KIRKLEES METROPOLITAN COUNCIL INVESTMENT & REGENERATION SERVICE

DELEGATED DECISION TO DETERMINE APPLICATIONS FOR CONSENT, AGREEMENT OR APPROVAL REQUIRED BY CONDITION

Reference No:	2025/44/93383/W
Site Address:	Hinchliffe Mill, Water Street, Holmbridge, Holmfirth, HD9 2NX
Description:	Discharge of details reserved by conditions 4 (design and appearance), 5 (archaeological investigation), 6 (boundary treatments), 9 (flood proofing), 10 (drainage scheme), 11 (flood routeing), 12 (temporary drainage scheme), 13 (lighting design strategy - biodiversity), 14 (Phase II Intrusive Site Investigation Report), 18 (electric vehicle charging), 19 (Construction Environmental Management Plan), 20 (highway retaining walls), 21 (surface water attenuation in highway), 22 (materials for retaining walls), 23 (Tree Protection Plan), 24 (Waste Management Plan), 25 (temporary waste arrangements), 26 (highway condition survey), 27 (re-surfacing scheme), 28 (parking layby scheme), 30 (CEMP: Biodiversity) and 31 (Landscape Ecological Design Strategy) of previous permission 2021/90800 for redevelopment and change of use of former mill site to form 19 residential units.

Officer Report

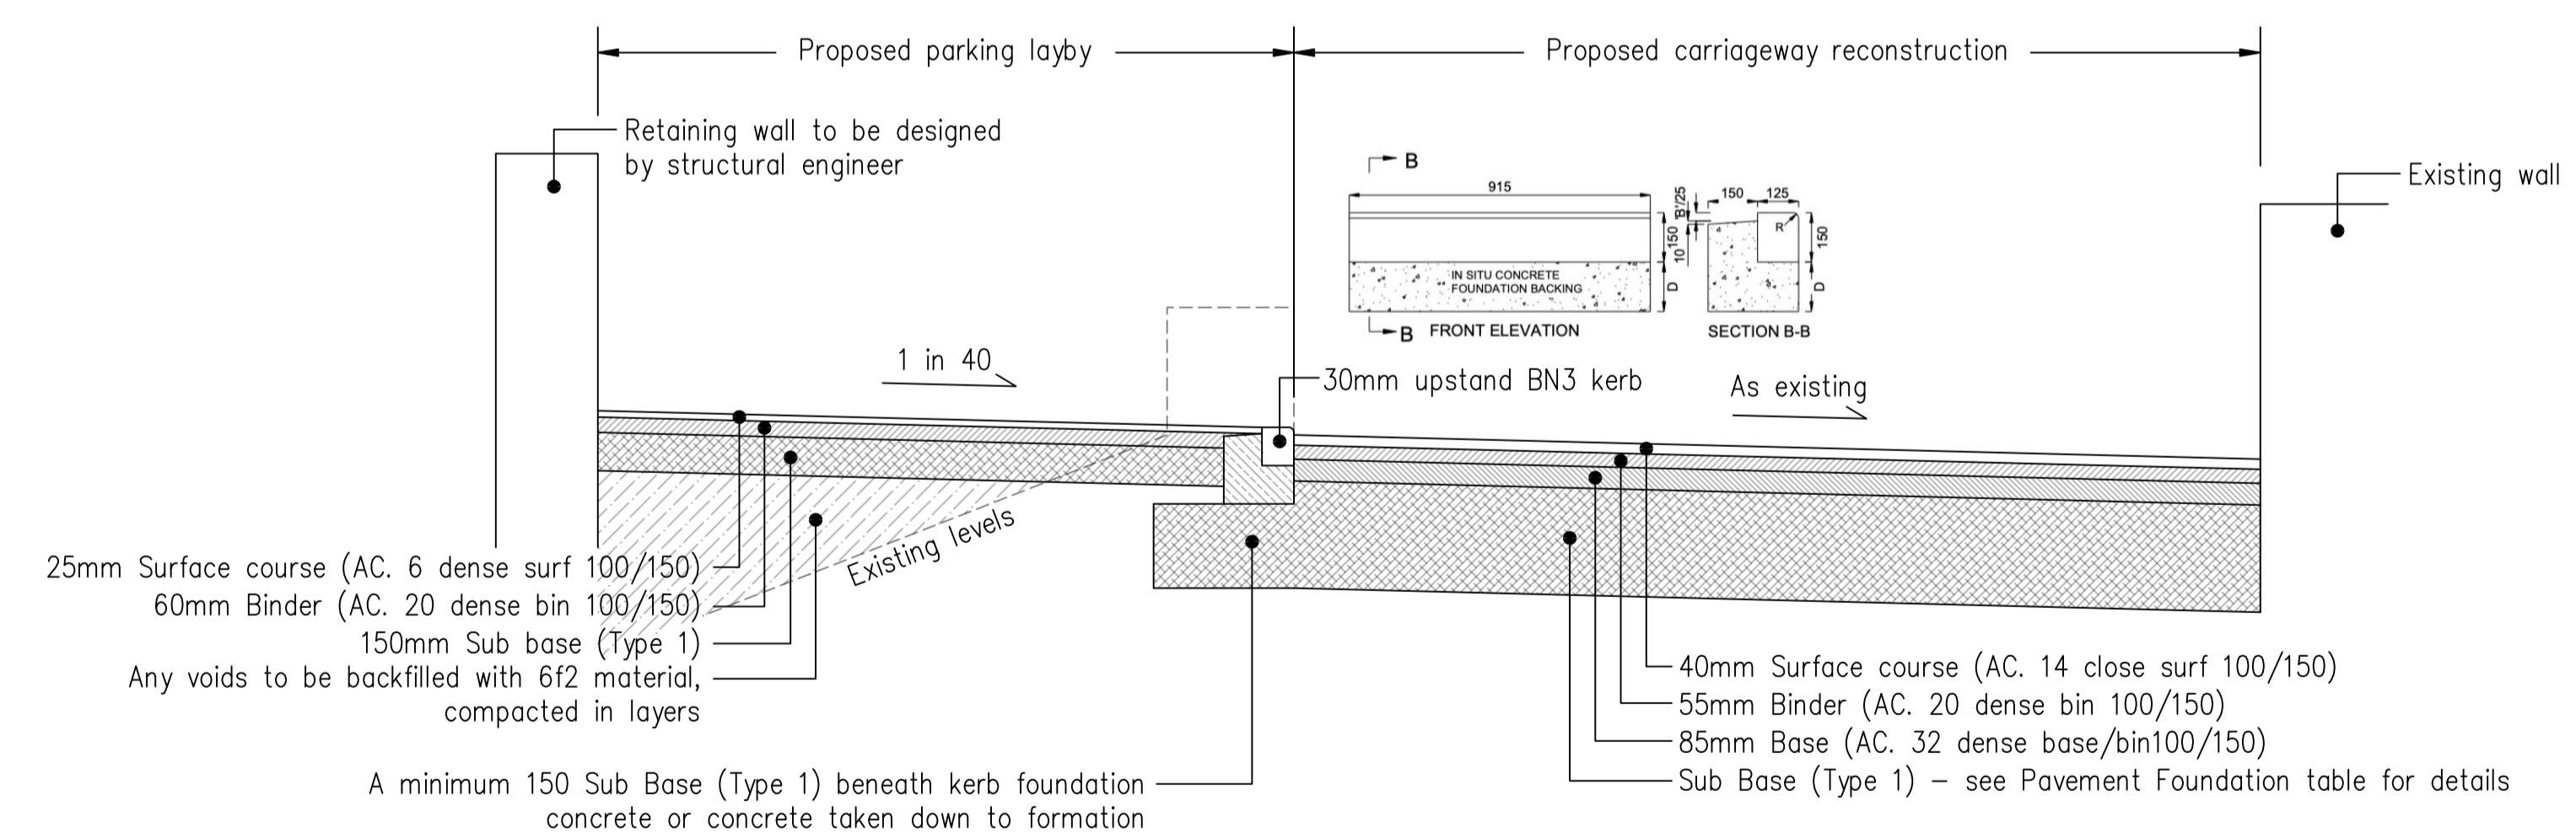
In principle, dry stone walls could be considered appropriate for this site, however clarification is needed regarding the proposed stone's source, and regarding the heights of these walls (drawing M3320-PA-04-V12 refers to "various heights" and "refer to engineers details", however on 02/04/2026 the applicant confirmed that there is no "engineers details" drawing, meaning it remains unclear how high the dry stone walls would be).

The proposed timber fencing (both the 1.2m high post and rail fence and the 1.8m high vertical timber hit and miss fencing) and the extent of its proposed use are of significant concern. At a site that, historically, never would have had such boundary treatments, the proposed timber fencing would appear incongruous. Different boundary treatments, more respectful of the history and appearance of the site and the Hinchliffe Mill Conservation Area, should be proposed instead.

Given the above assessment, and the concerns regarding the proposed timber fencing and the lack of clarity regarding the materials and heights of the dry stone walls, it is recommended that approval of the details (submitted pursuant to condition 6) be refused.

PLANNING CONDITION DRAWING

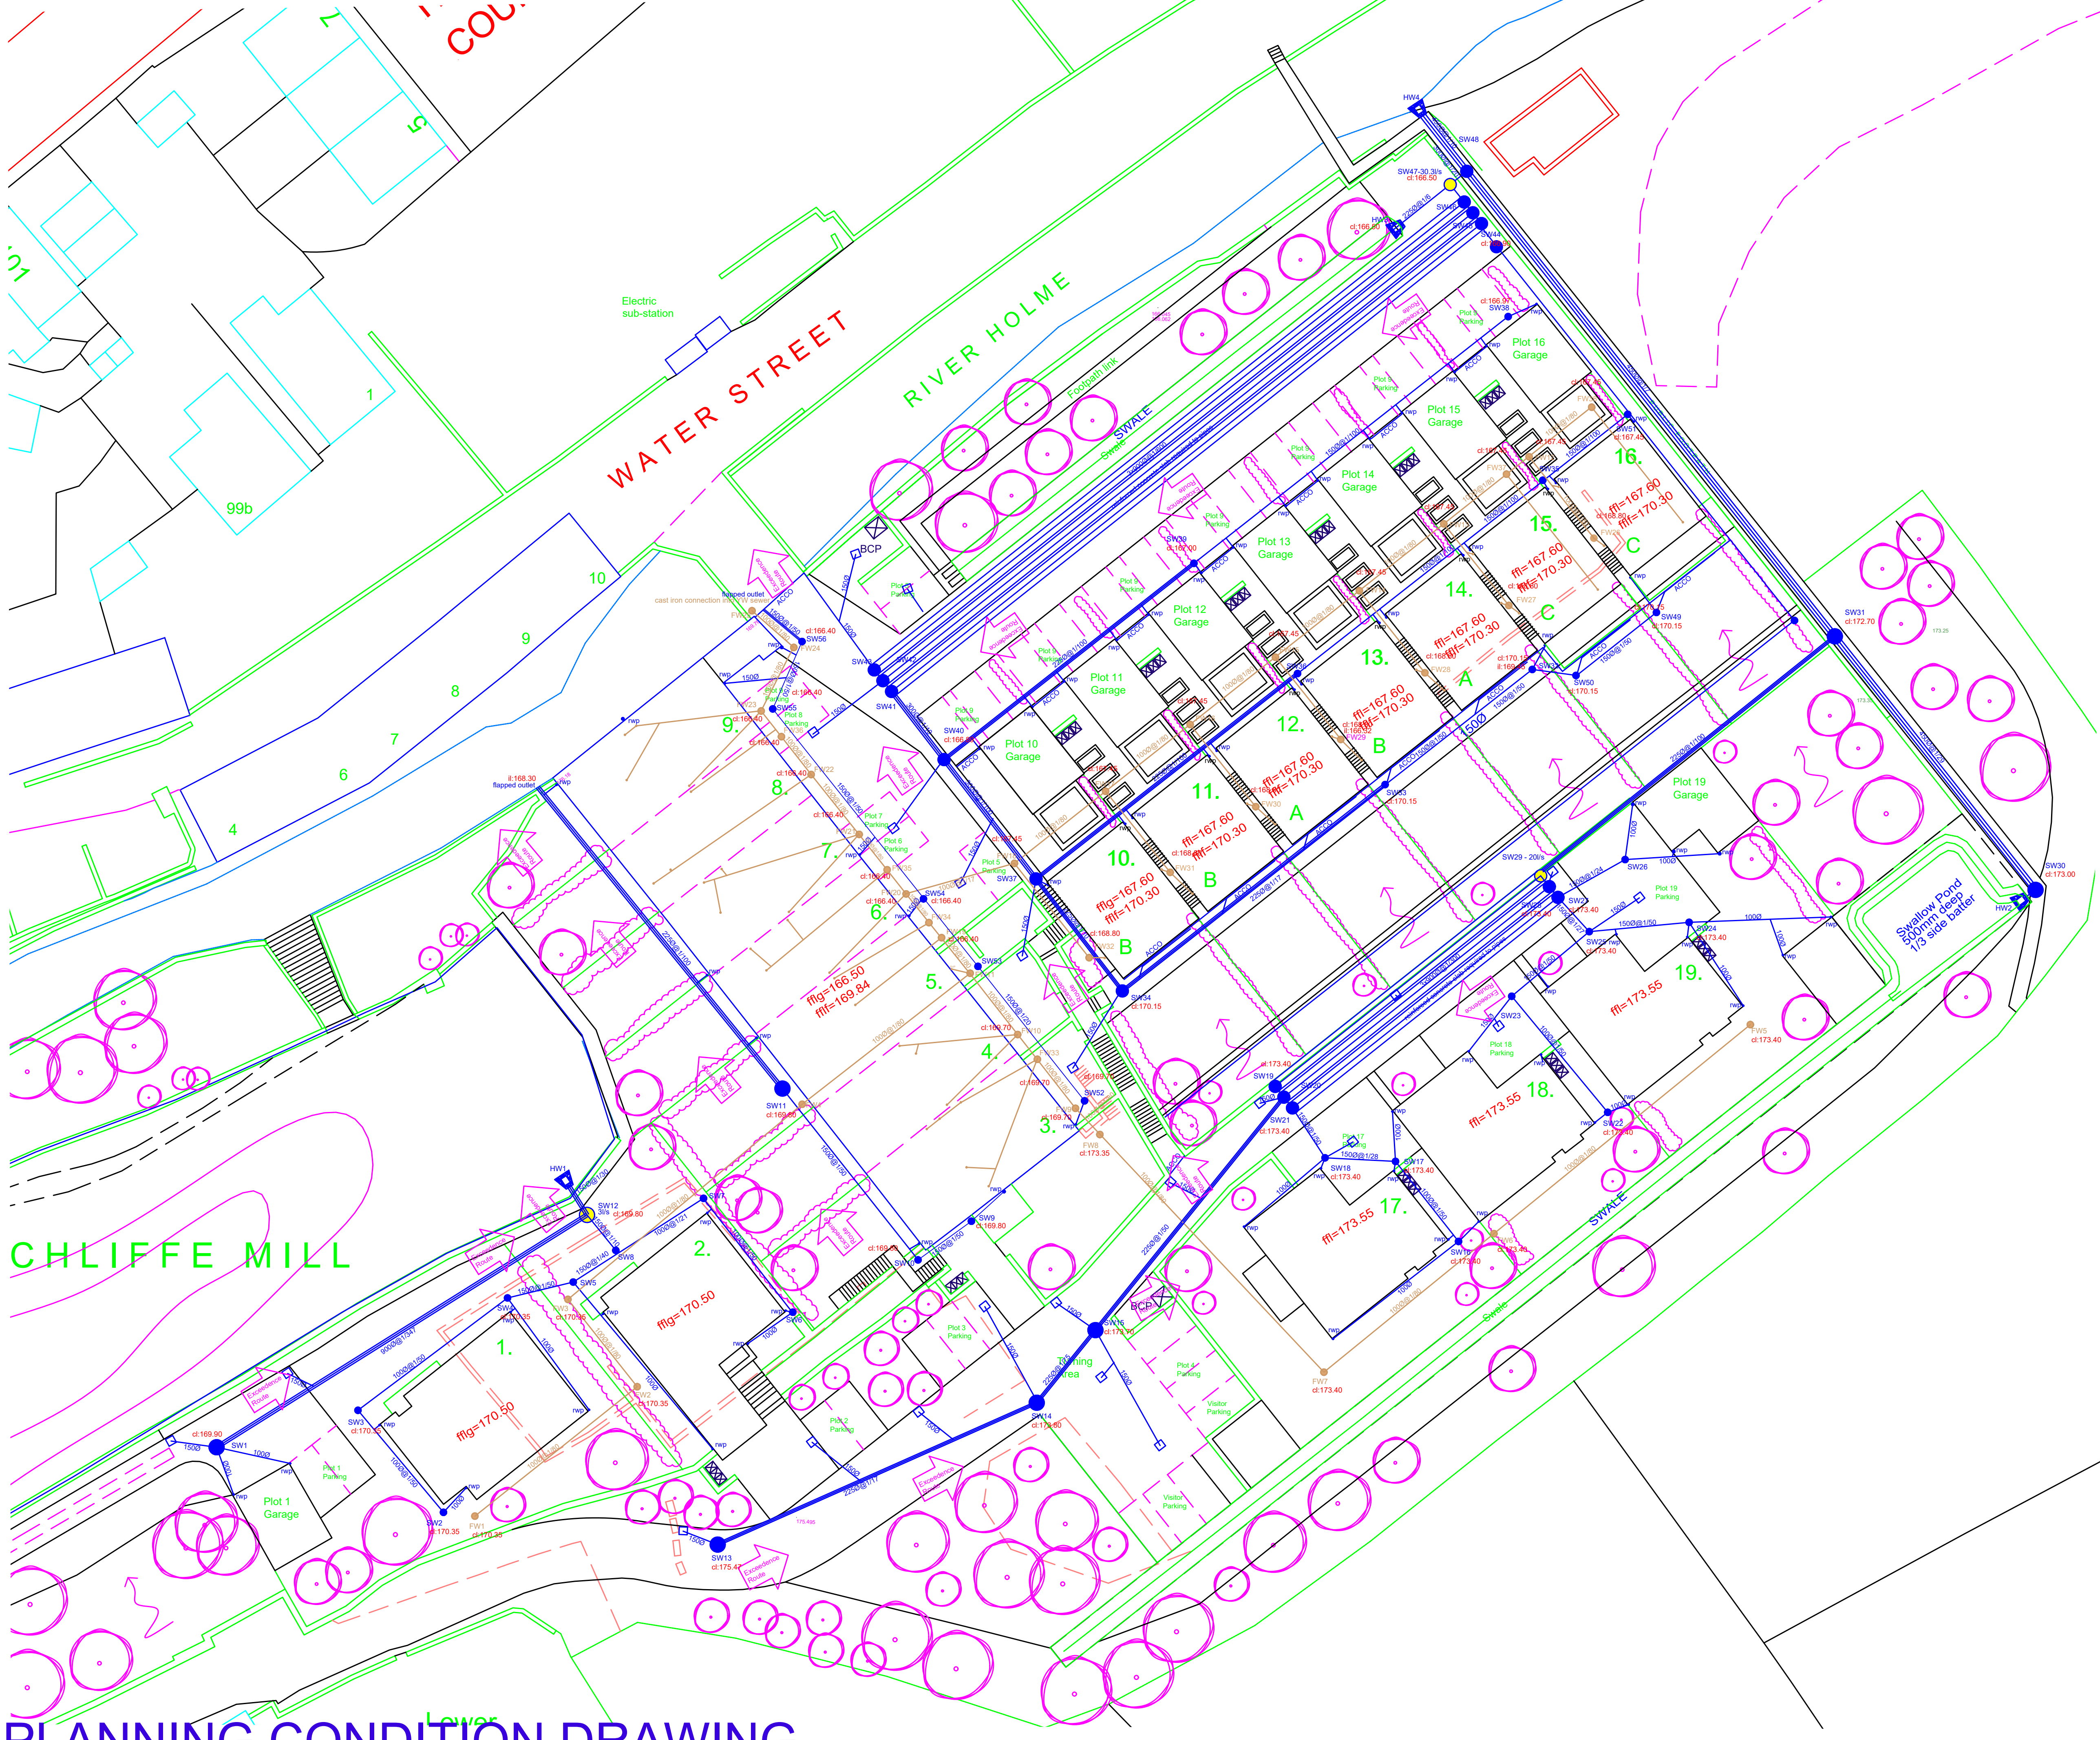
The revised report (2025-3388, Drainage Conditions, Rev D) has been updated, however it is unclear where the flow control devices for each of the areas (Areas 1, 2 and 3) are located as the MH reference numbers given in the Notes are not indicated on the drawing. The drainage drawing (EWE/3388/01 Rev D, dated 11/02/26) indicates headwall HW1 draining to the existing Mill Pond and headwall HW4 draining to the river but there is no other apparent headwall location to account for the 3rd discharge point.

The developer should clearly indicate on drawing EWE/3388/01 the location of each of the flow control devices together with its associated discharge rate, design head, outlet diameter, and Invert Level to allow the LLFA to cross-check the inputs in the Hydraulic Calculations in Appendix C, D and E.

The total lengths of the 900mm dia pipes should be indicated on the drawing to allow the LLFA to cross-check the inputs in the Hydraulic Calculations in Appendix C, D and E.

A further submission of the documents addressing the points made above is required and therefore Condition 10 cannot be discharged.
